Re: MMC Staff Parking Garage | 222 St. John Street | Level III Site Plan
Design Change

The purpose of this memorandum is to summarize changes made within the attached revised design drawings since the initial Level III Site Plan Submission on June 22, 2018.

Drawing file: Drawings / 7_C-103_Grading & Drainage Plan - 2.pdf

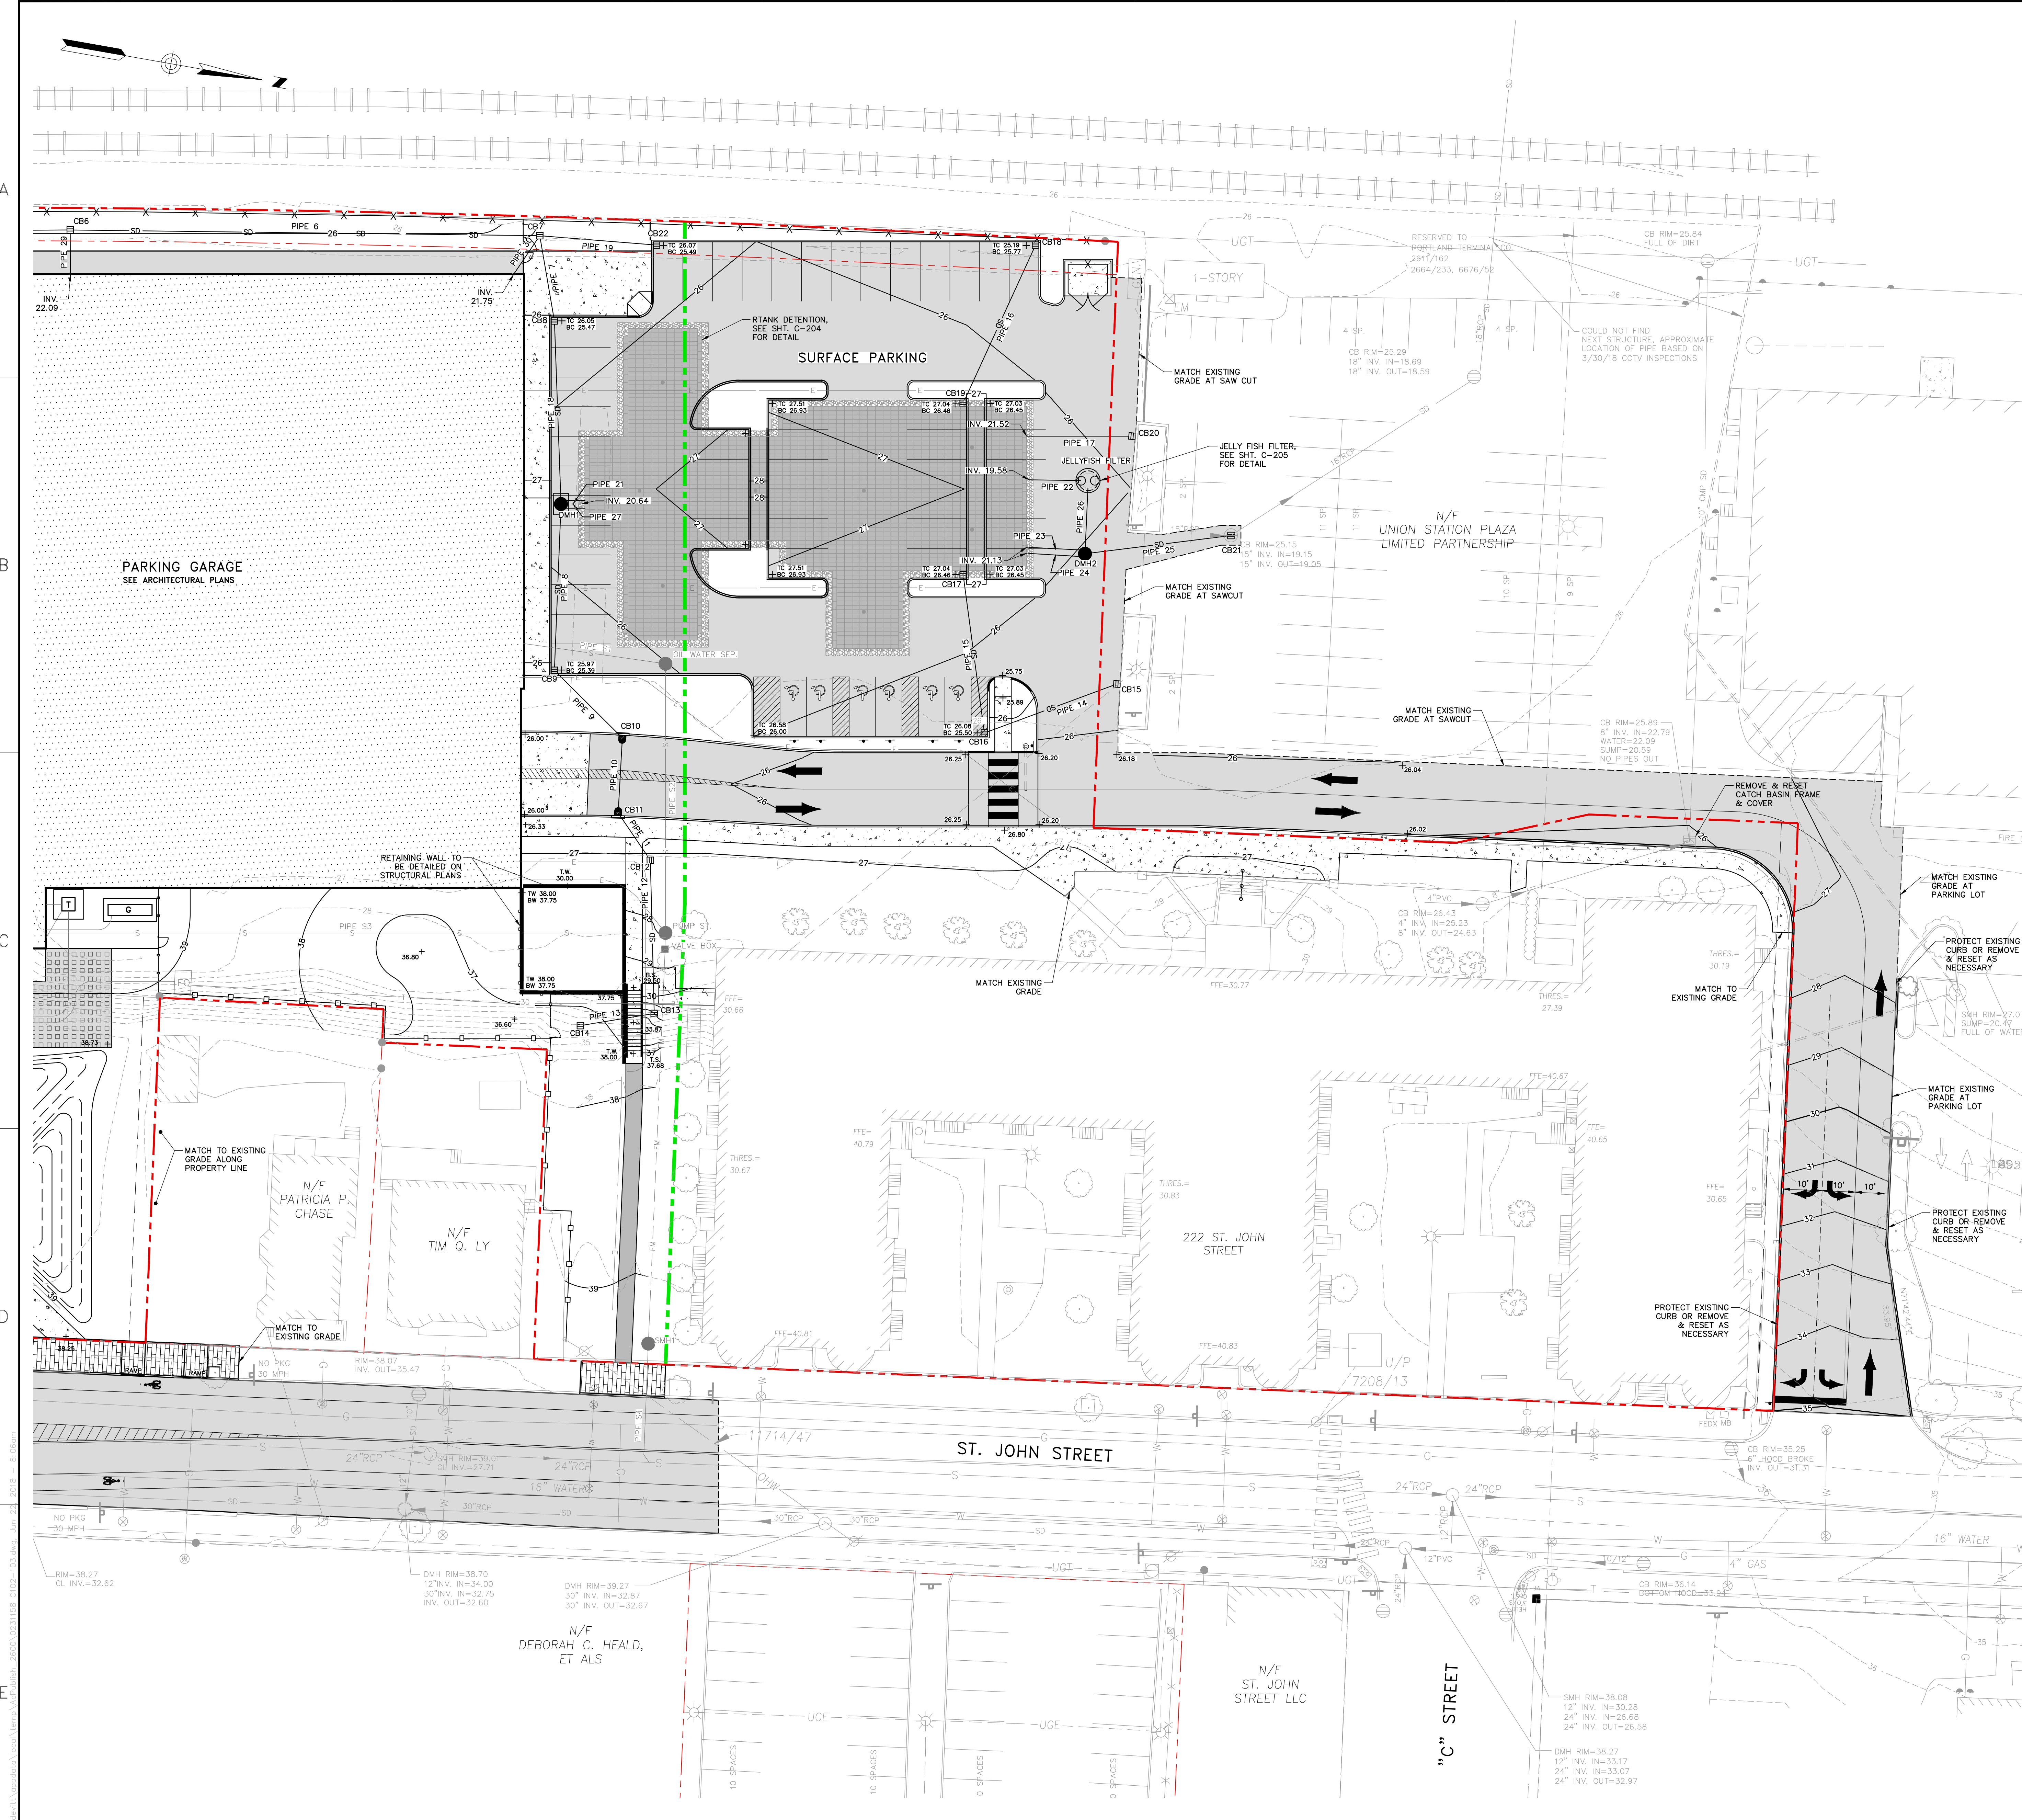
- Reconfiguration of grading adjacent to the pedestrian walkway from the northeast corner of the garage to St. John Street. Grading has been revised along the northern edge of proposed stairs; narrow strip of stone armoring added immediately adjacent to stairs to provide stabilization and prevent erosion.
- Revised grading along Union Station Plaza entrance, proposed grades have been revised to match existing grades.

Drawing file: Plans / 30 PS6 Level Parking Layout.pdf

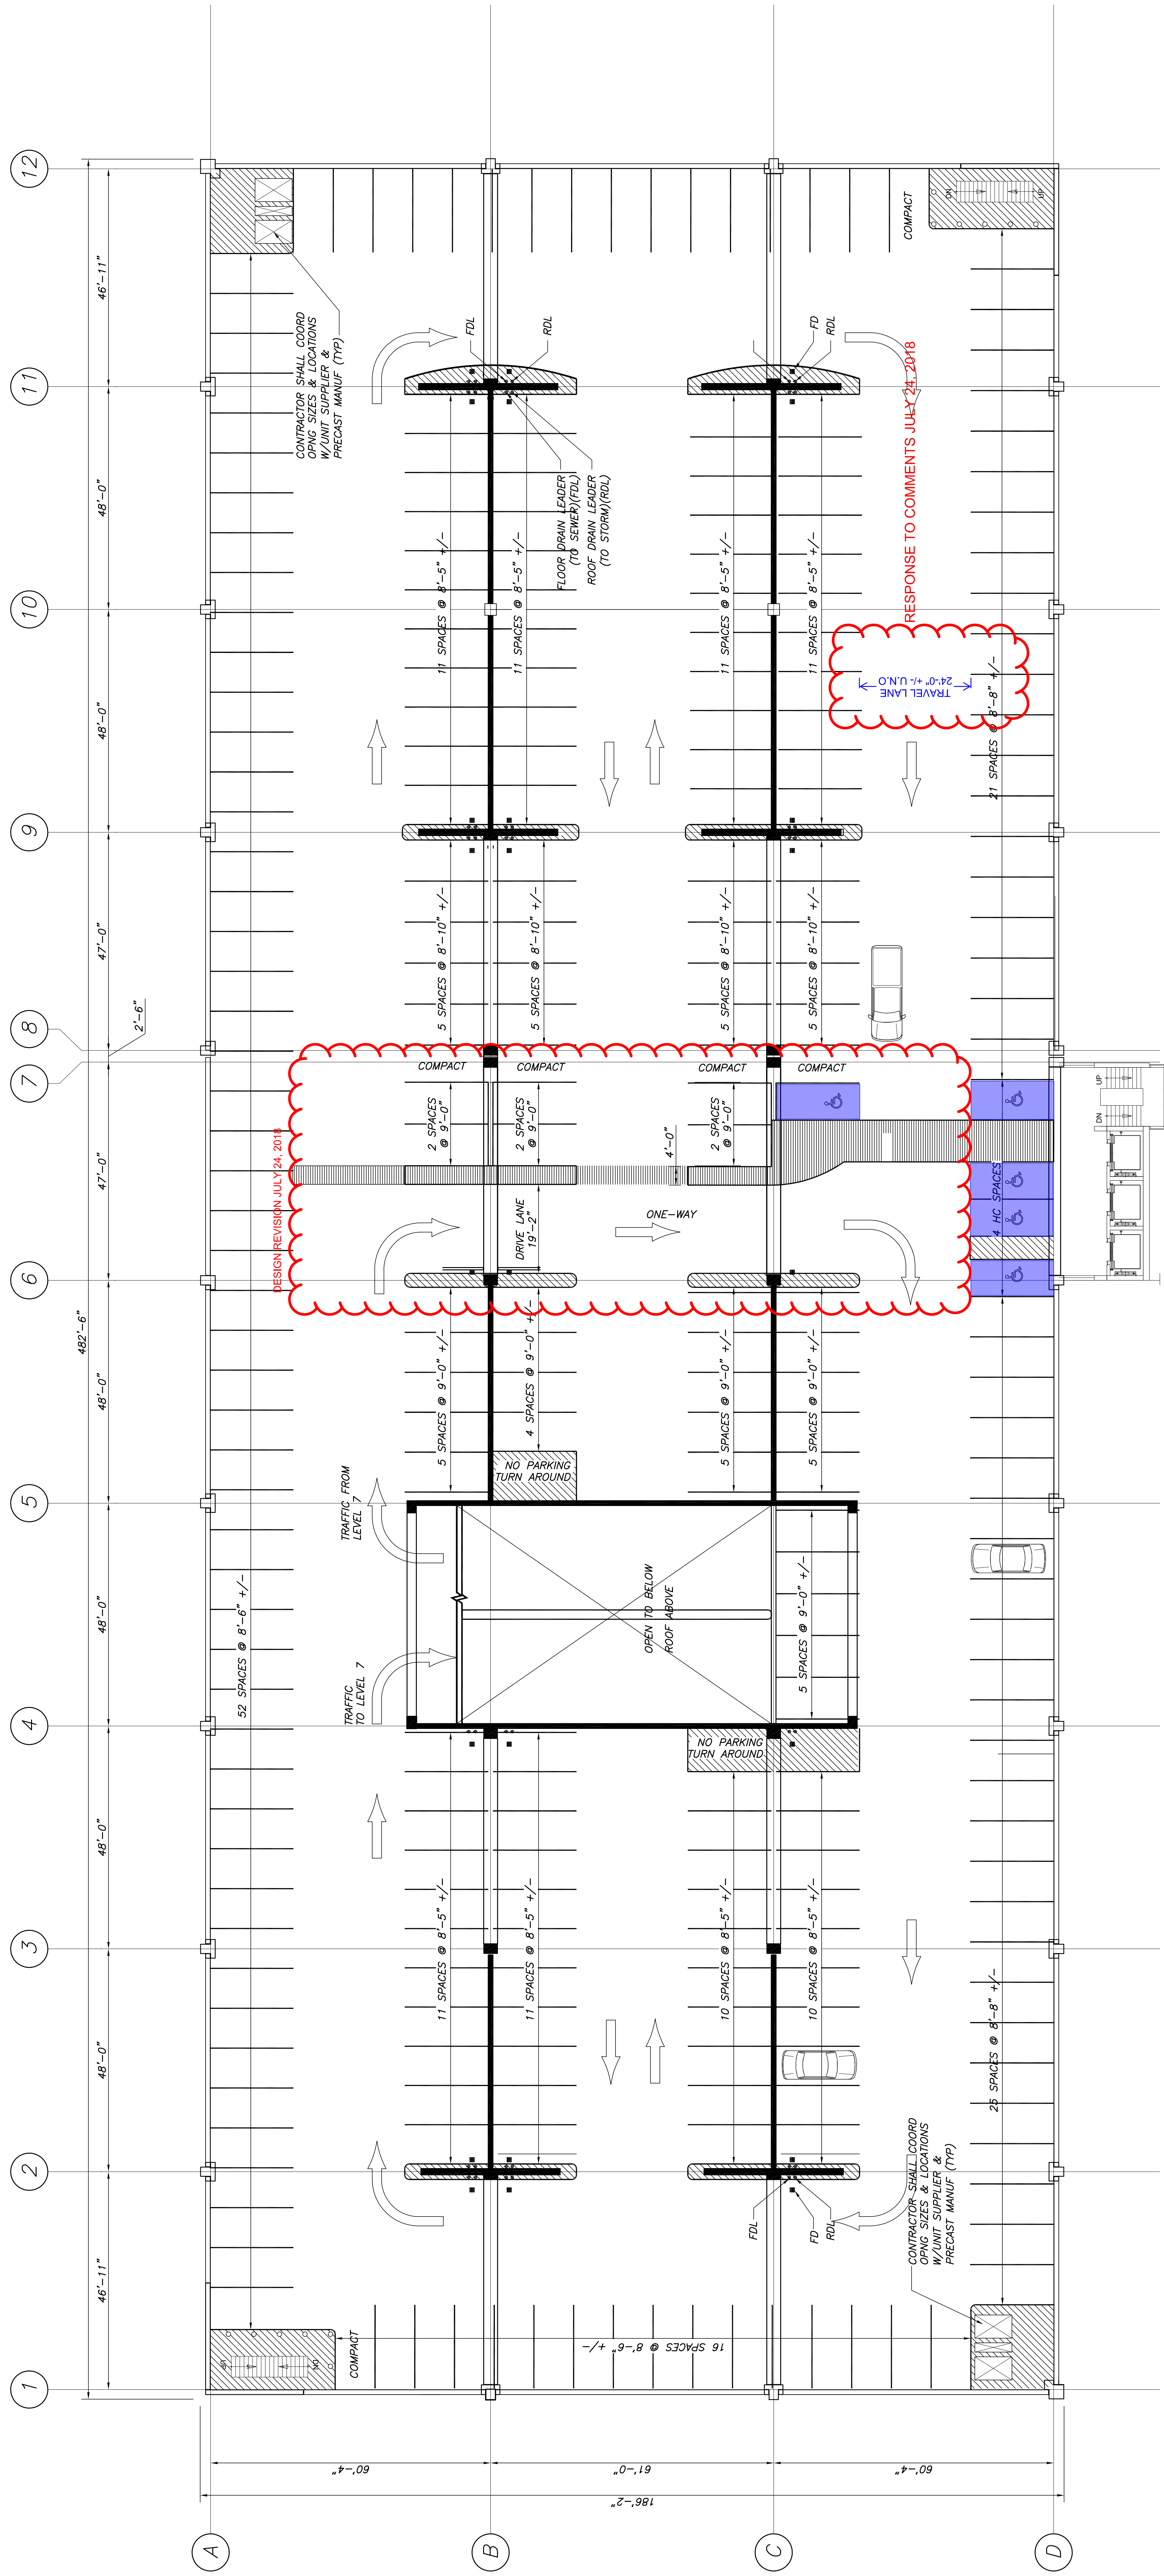
- Revised garage layout to accommodate separate 184 St. John Street entrance and parking spaces.
- Relocated van accessible spaces to level G and reduce floor to floor level 1 and level 2.
- Design layout changes within travel lane.
- Adaptational travel lane dimensions.

Drawing file: 7. Final Approved Plans and Documents / MMC Employee Garage_elevations.pdf

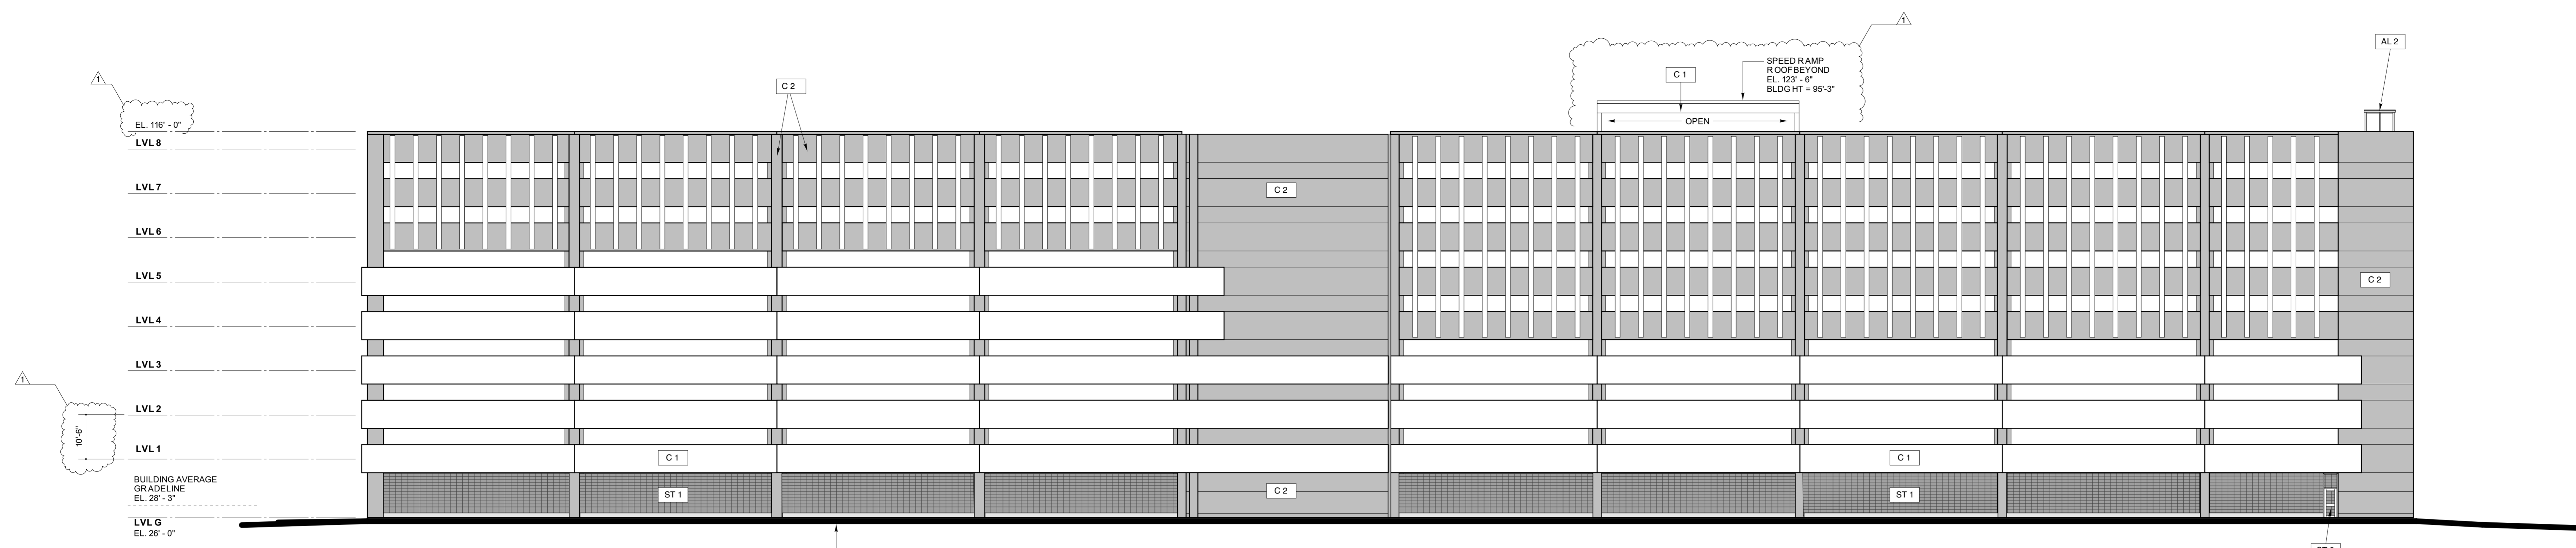
- Revised east façade to accommodate entrance for 184 St. John Street users (Eagles).
- Enlarged canopy over entrance area in response to City comments.
- Added windows at electrical / mechanical rooms in response to City comments.
- Reduced the floor to floor height of the first deck level (lower) by relocating van accessible spaces to level G; revision resulted in a reduction in the overall building height (revisions to elevation call outs)
- Removed the screening wall above the stair tower due to changes in mechanical equipment
